Application No: EP/48/21/HH
Site Address: 2 Bay Tree Garden East Preston BN16 1JG
Description of works: Erection of single storey rear extension and rear dormer following the demolition of existing garage and workshop.

This council's Planning & Licensing Committee has considered this Application electronically.

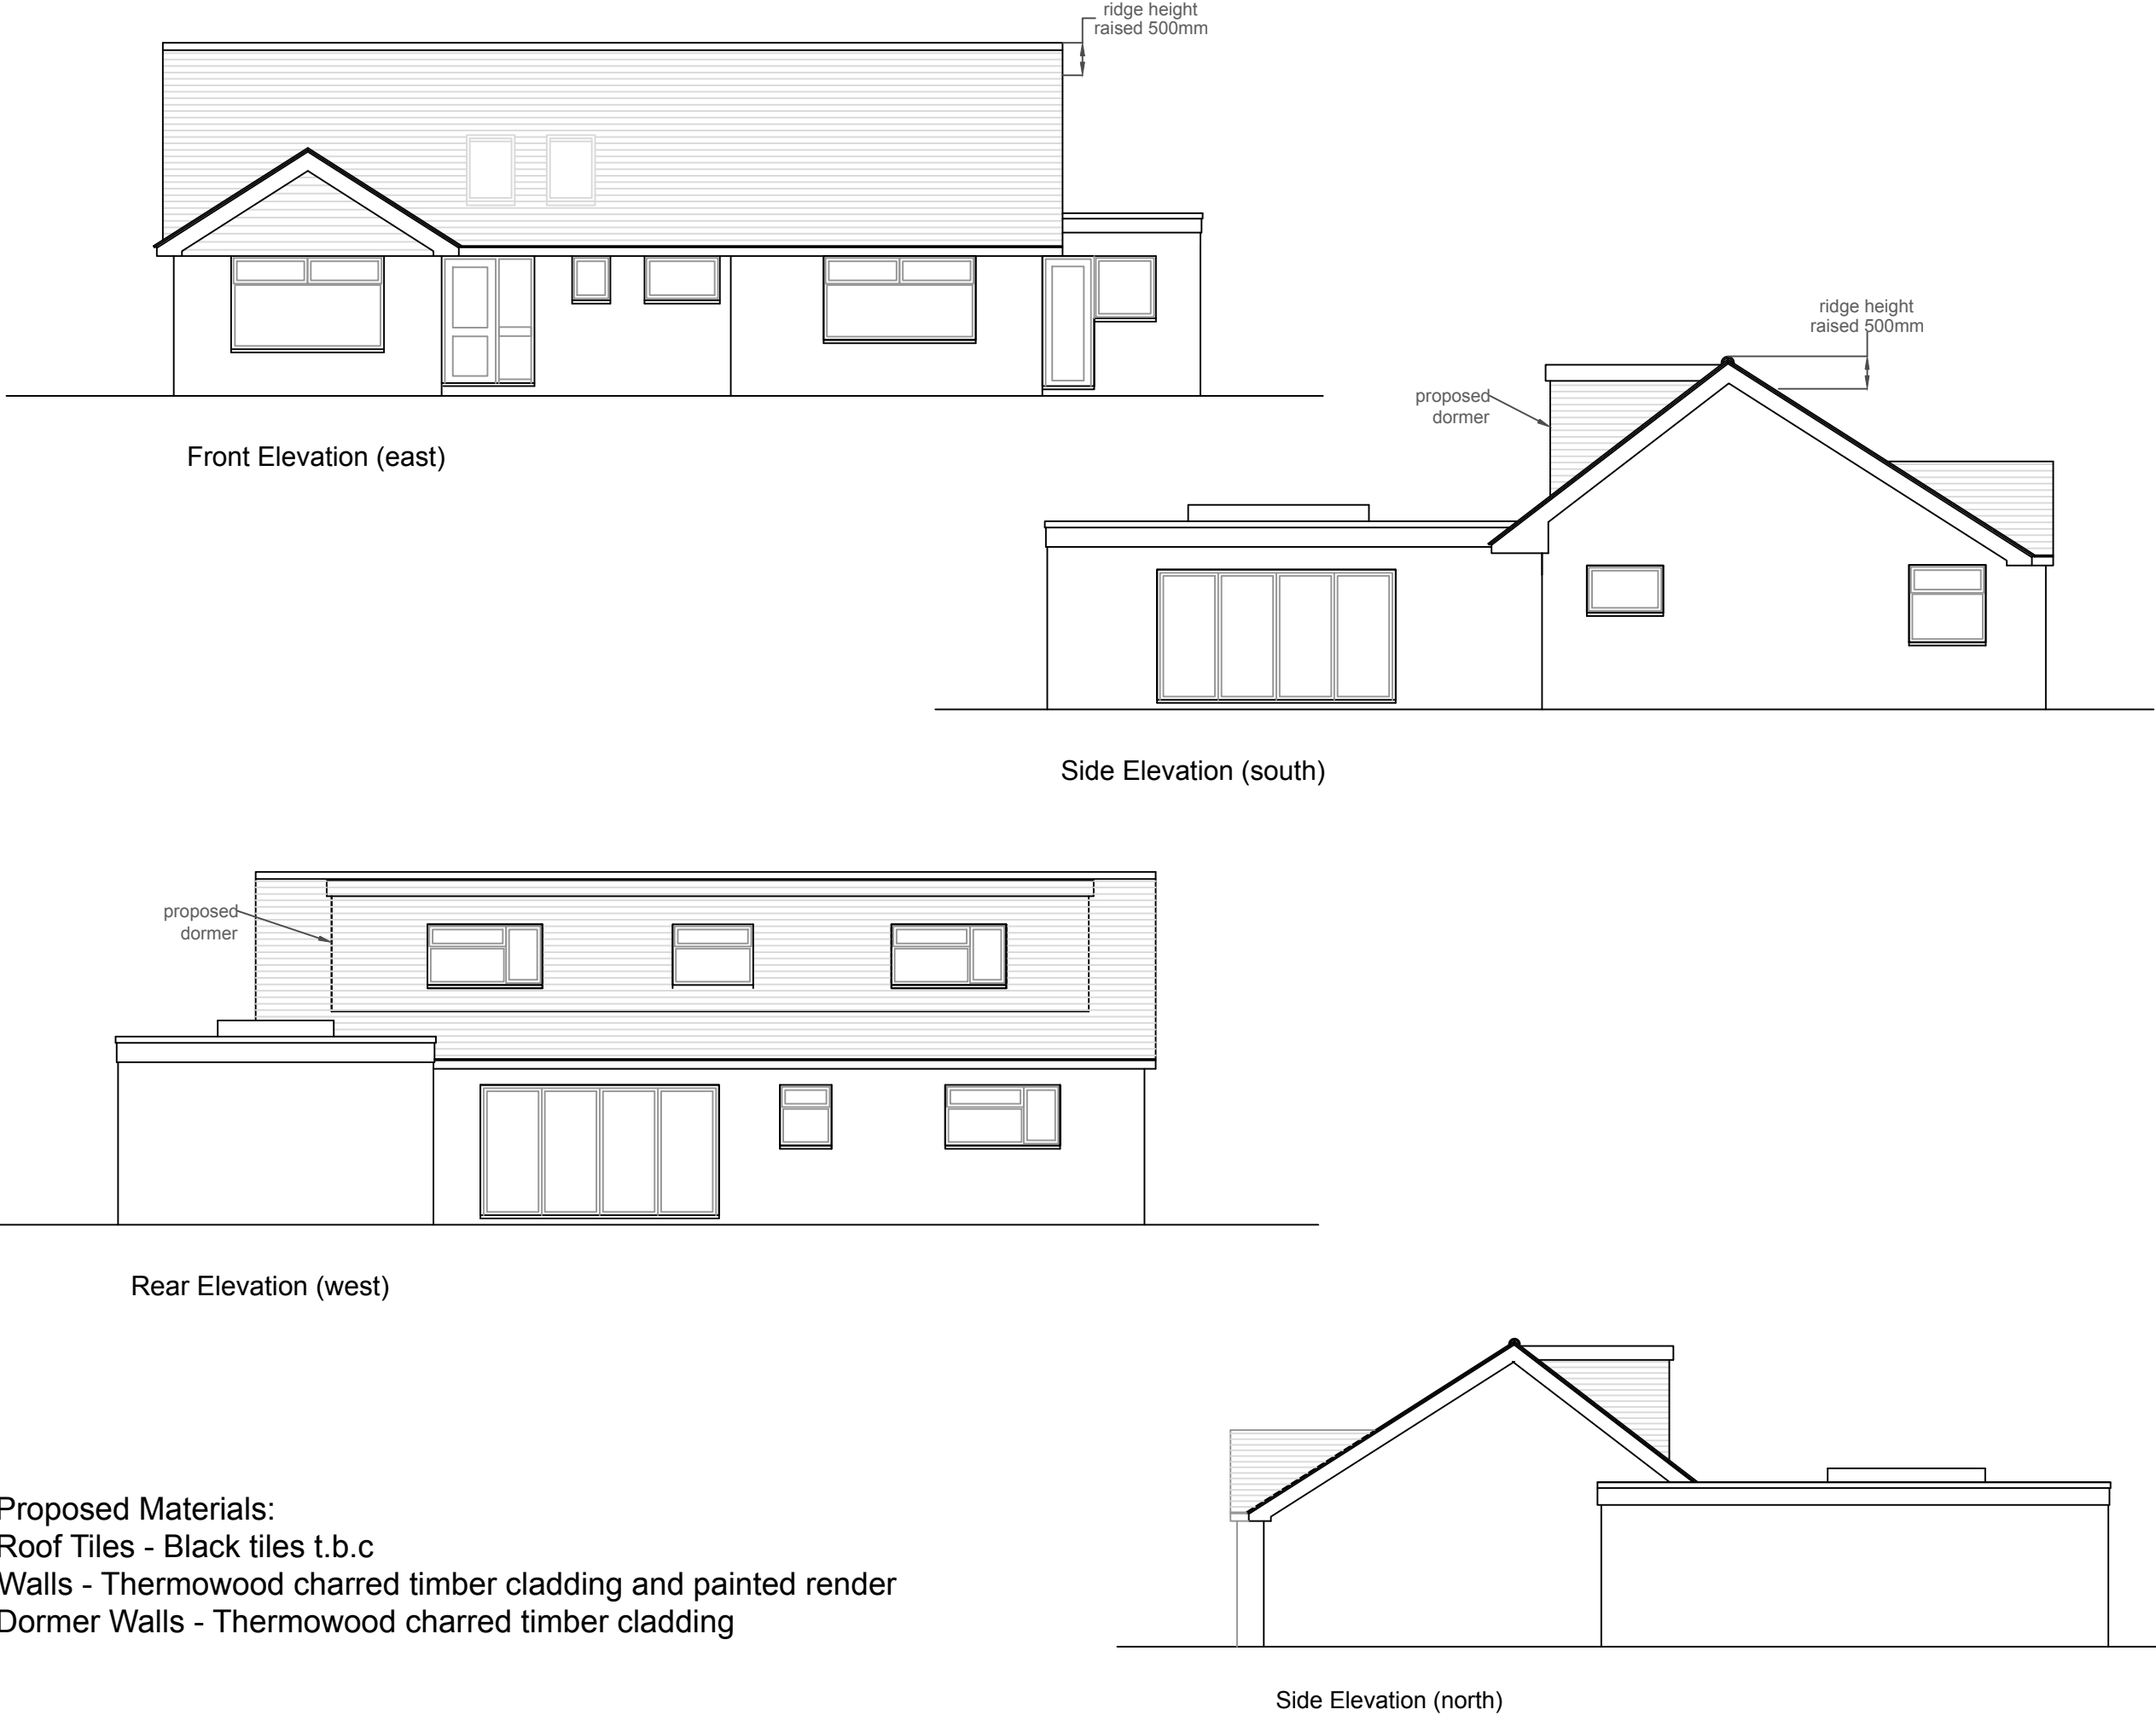
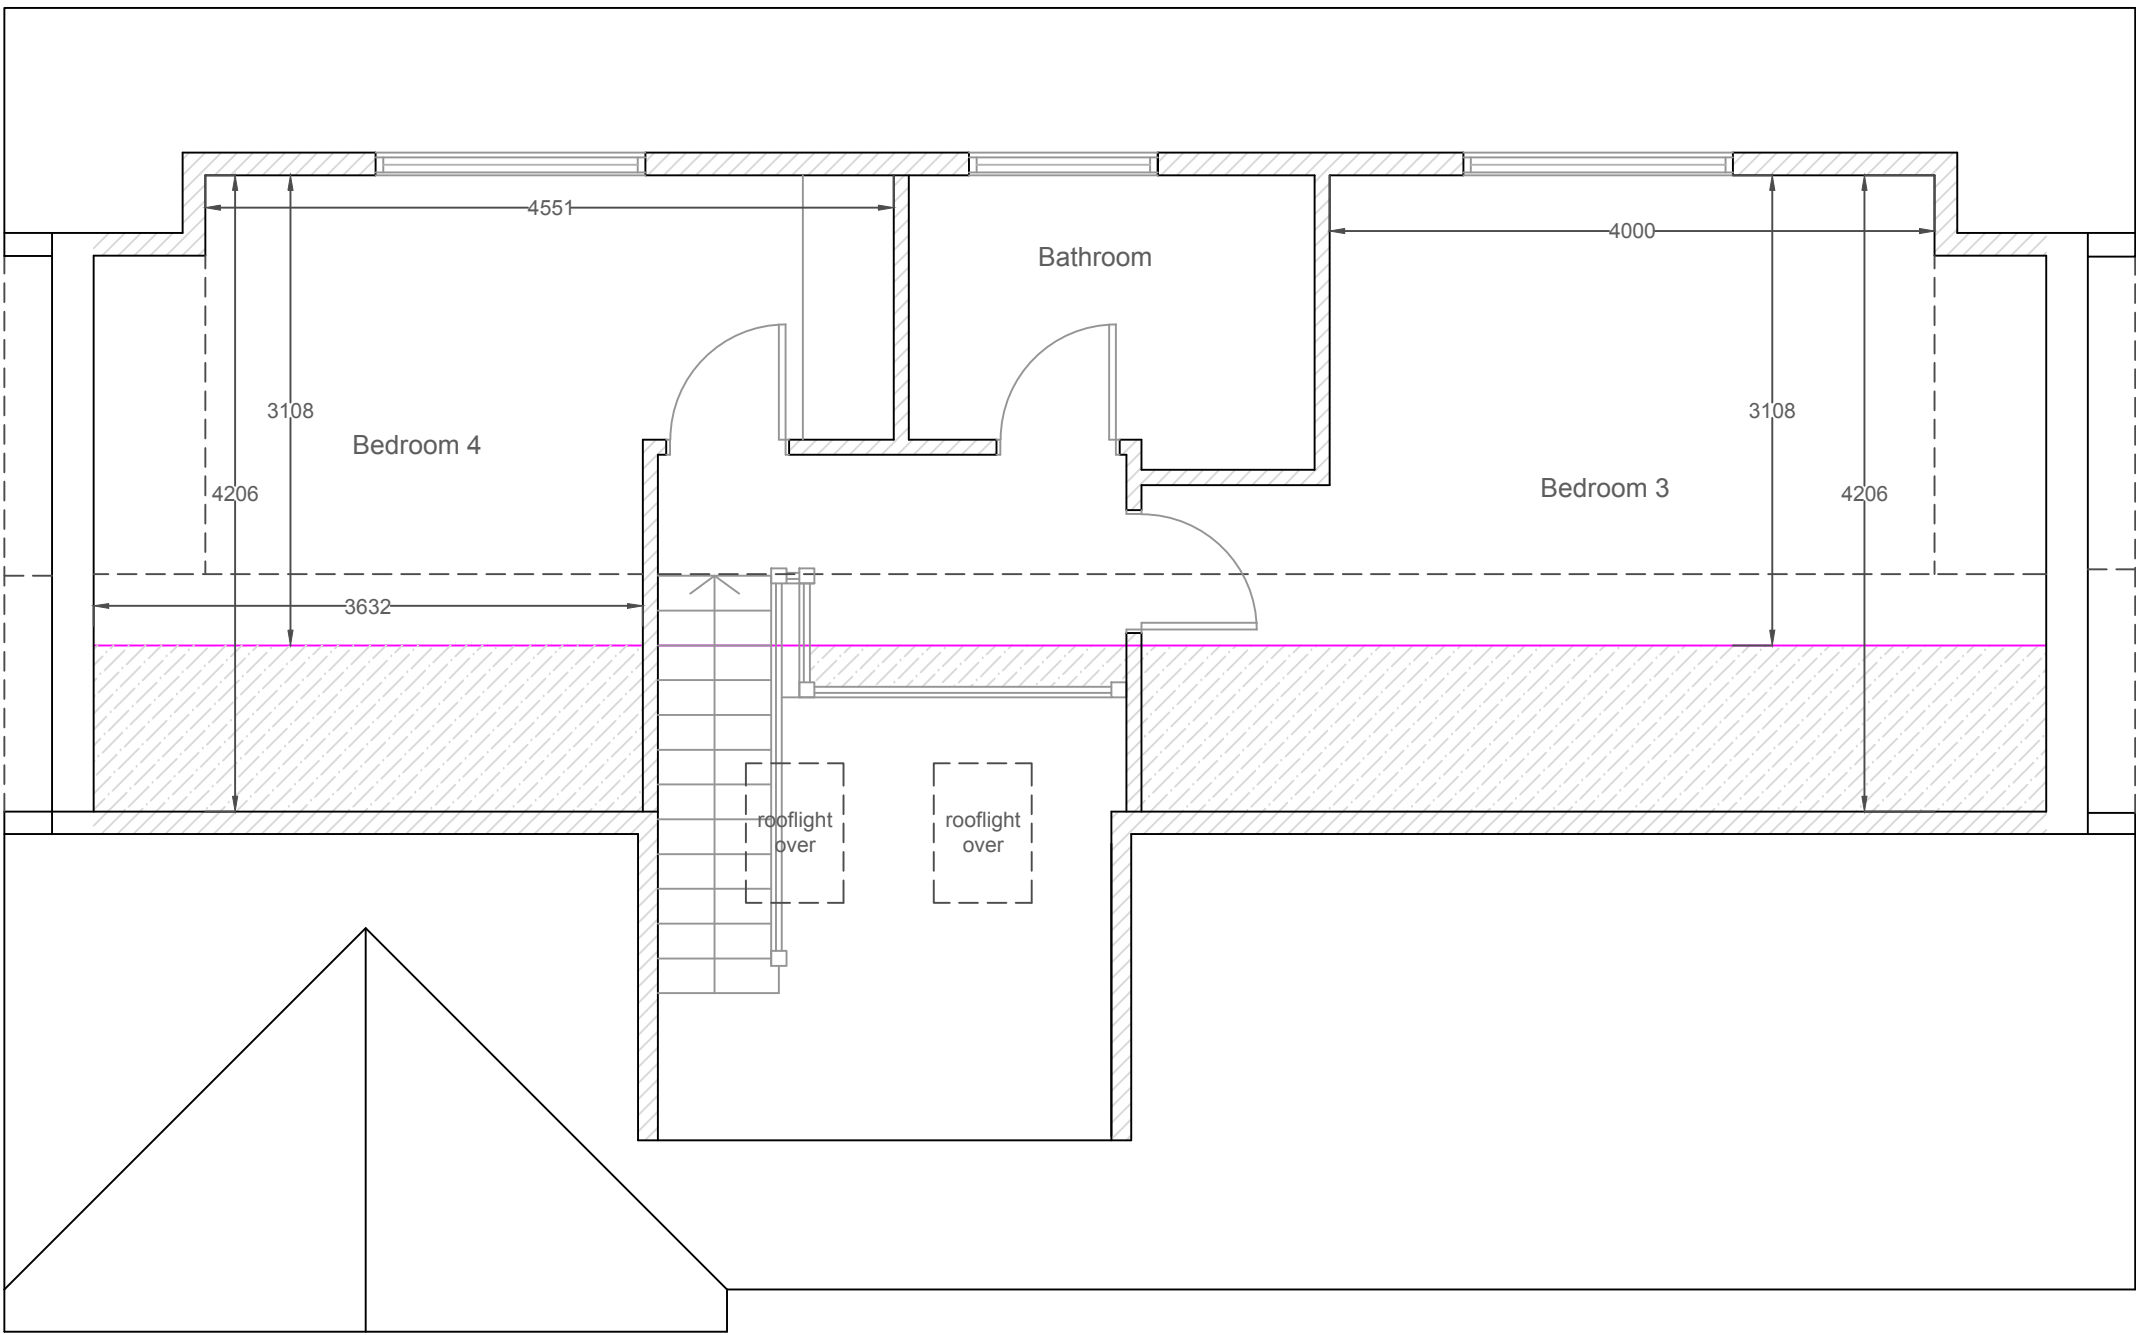
There is a possibility the proposal will result in an increased amount of overlooking of the properties to the west of the application site.

The committee also feels the proposed materials may not be in harmony with the surrounding area in colour and texture. This would be contrary to Policy 1 of the East Preston Neighbourhood Plan and Policy D DM1 of the Arun Local Plan.
